Willington Parish Council

23 July 2026

Response to the Castle Way Energy Scoping Consultation – Your Ref EN0110037

PROJECT Castle Way Energy
 DRAWING TITLE Figure 3.2: Cable Route Corridor Option Colours
 CLIENT BSSL Derbyshire 1 Ltd

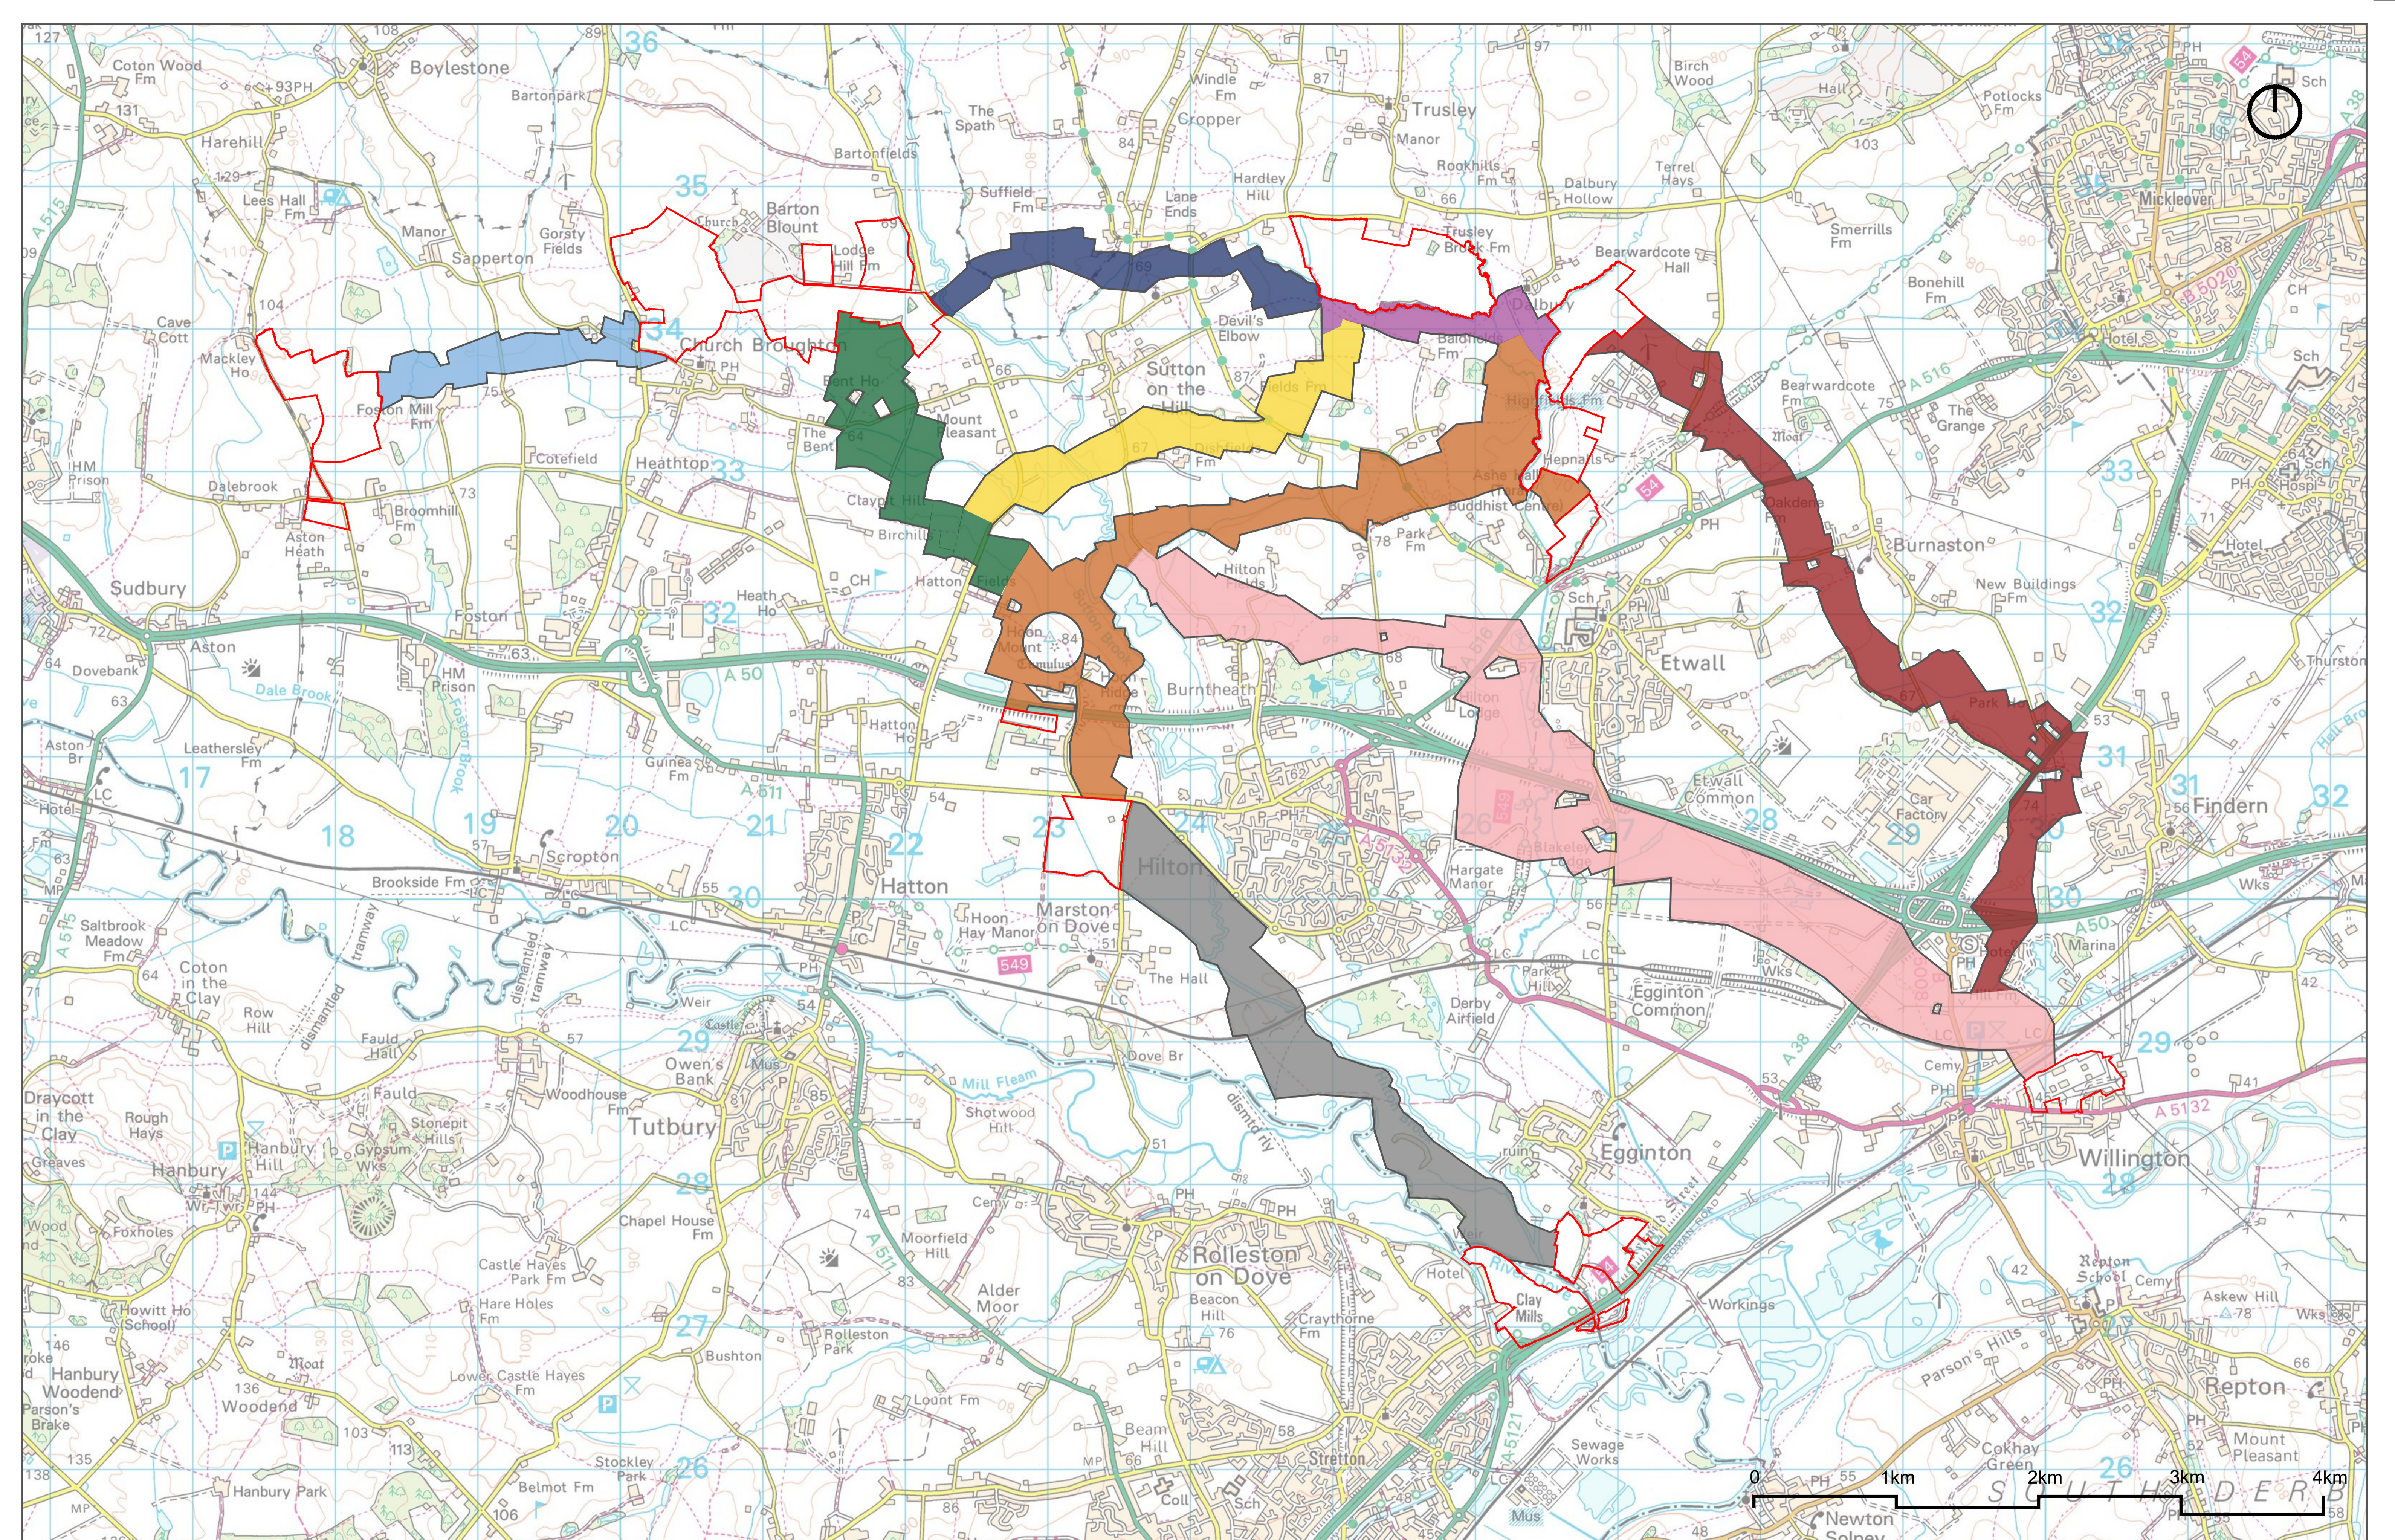
The Council would like to see greater exploration of opportunities to connect into existing or proposed electricity infrastructure rather than creating entirely new corridors.

In particular, we believe the Environmental Statement should consider whether closer integration with the proposed Chesterfield–Willington National Grid reinforcement could reduce the amount of new infrastructure required through open countryside.

The Council also requests that the proposed cable route is assessed against planned development within the village.

In particular, consideration should be given to the proposed retirement living development and whether alternative routes could avoid unnecessarily constraining future regeneration opportunities.
